Welwyn Hatfield Borough Council

Appeal by: CUFFLEY PROPERTIES LTD

Everest House, Sopers Road, Cuffley, Potters Bar, EN6 4SG

Written Statement of Local Planning Authority

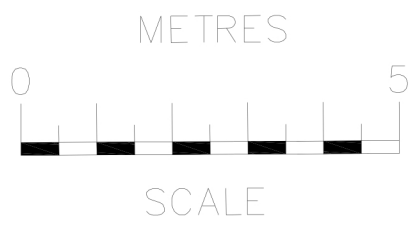
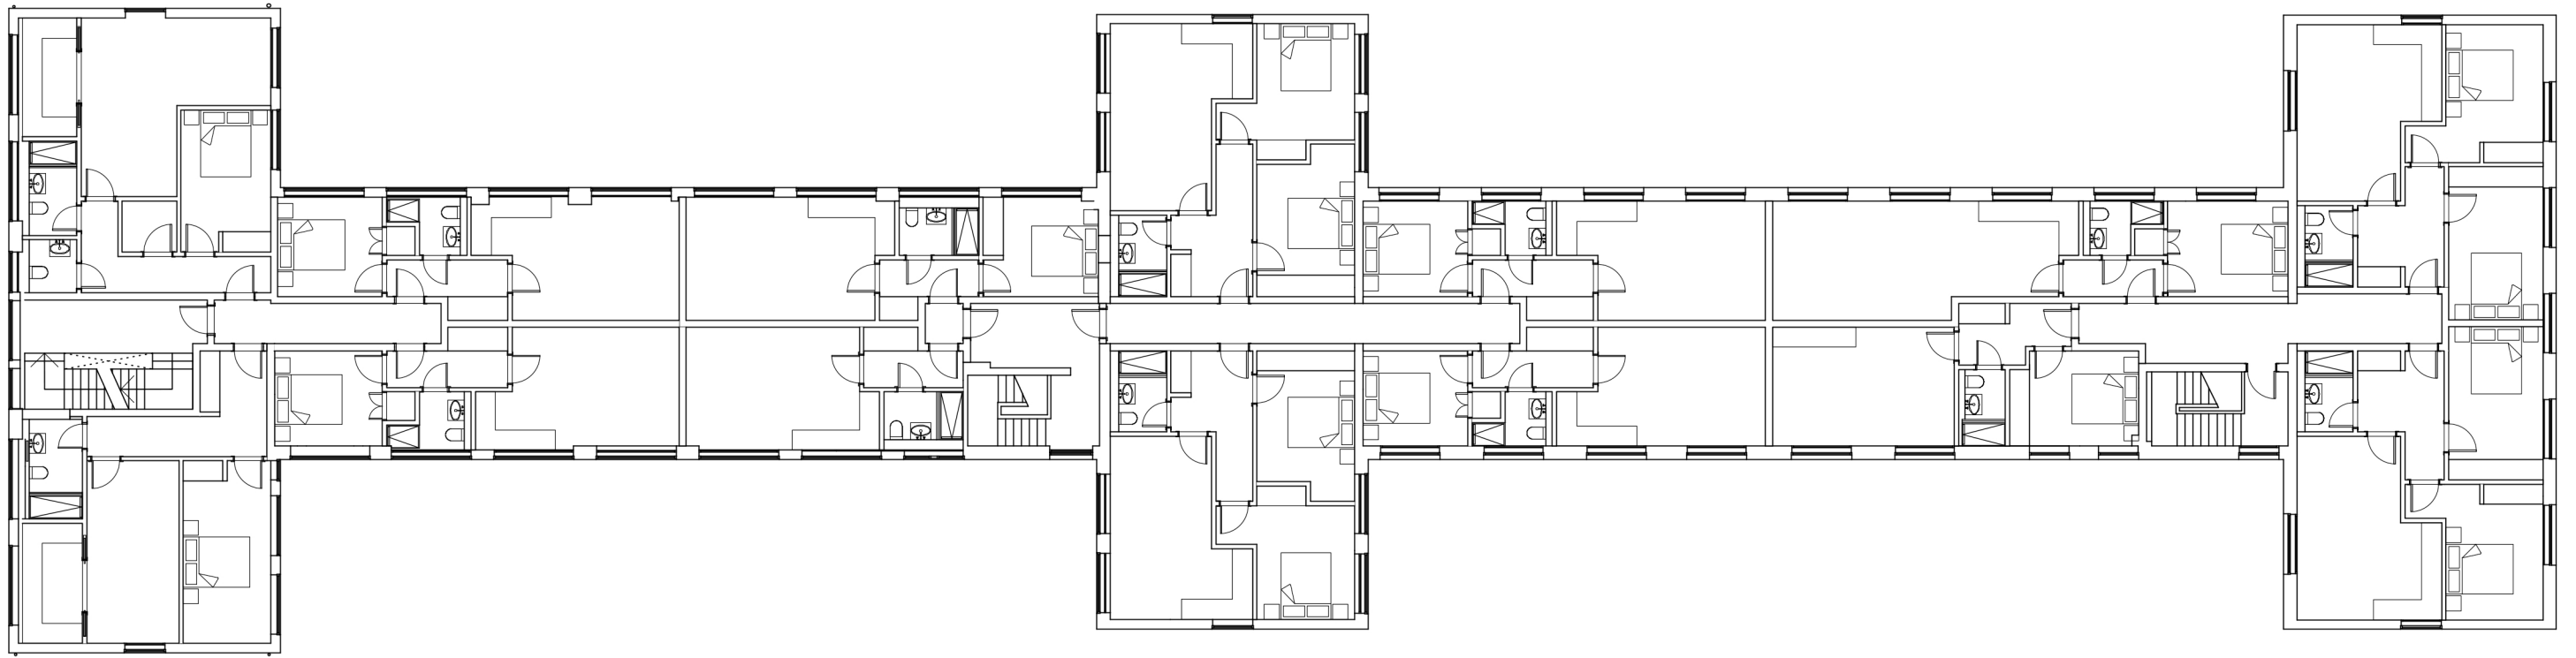
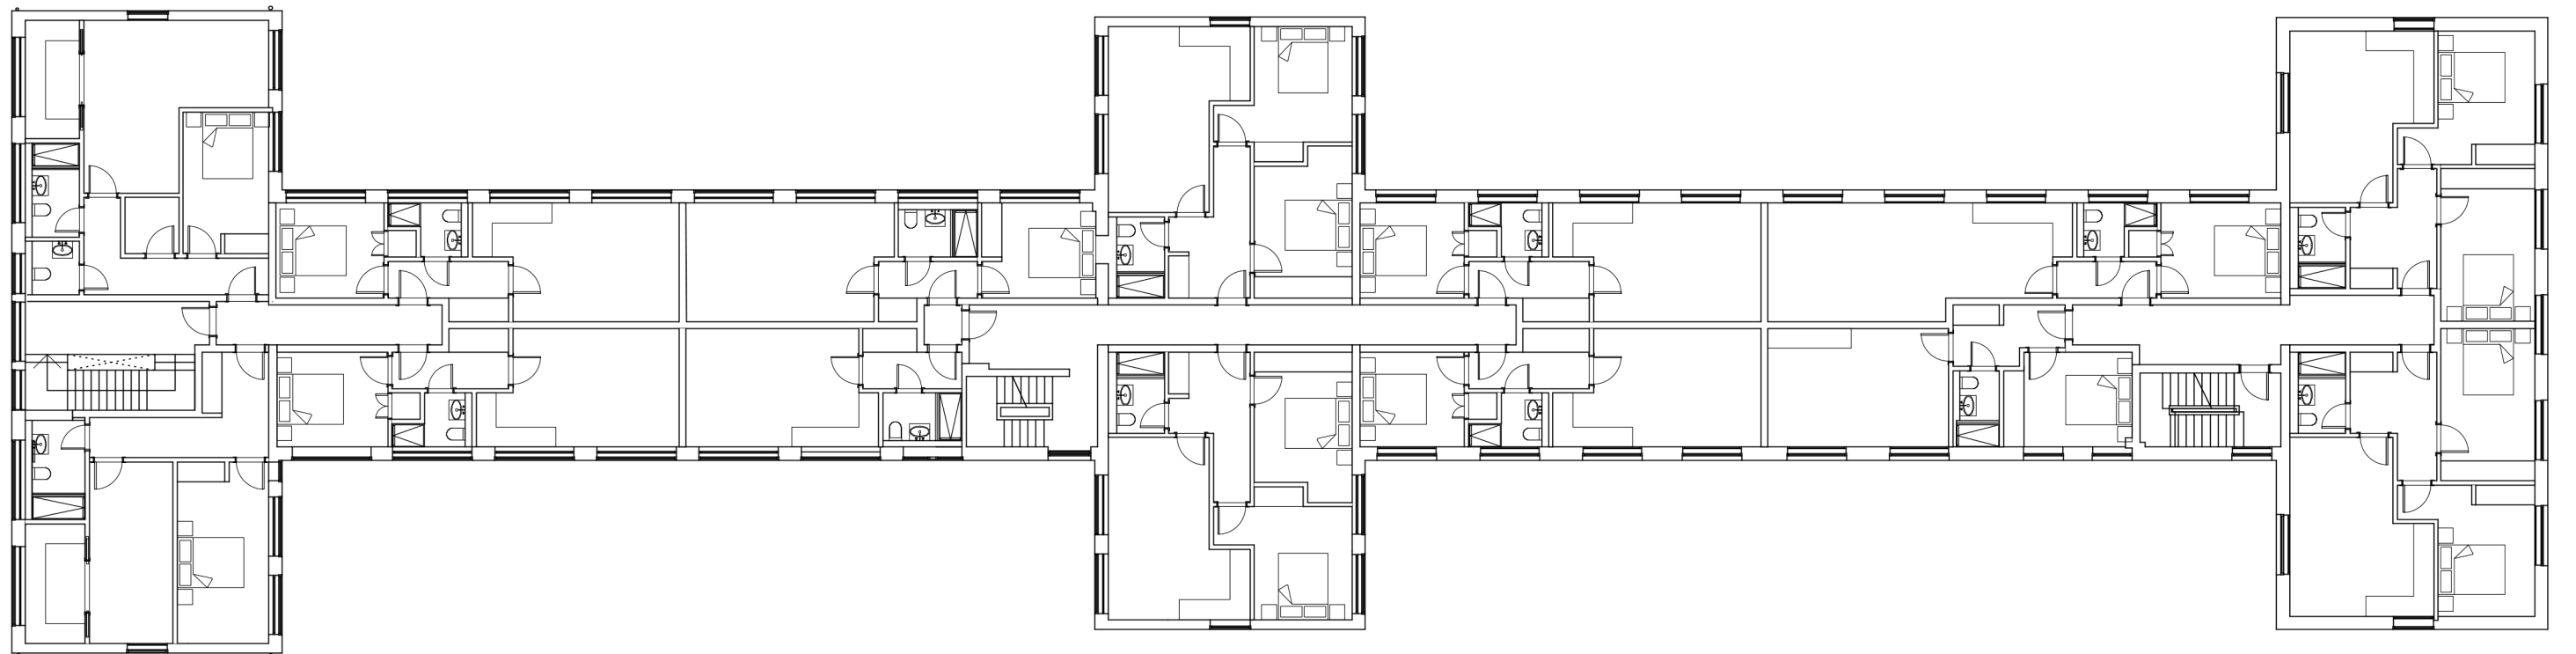
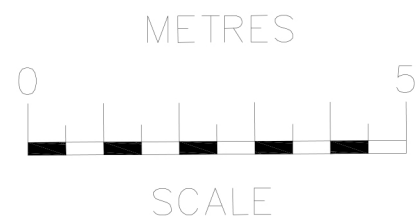
- 3.19 A varied layout is presented by the appellant under this appeal however it is considered that the analysis of impact remains substantially in excess of any acceptable criteria and unacceptable levels of noise would still arise.

- 1.17 The varied designed also do not change the analysis of impact which remains substantially in excess of any acceptable criteria.
- 1.18 There appears to be a fundamental misunderstanding amongst some acousticians on two levels and arising in this case:
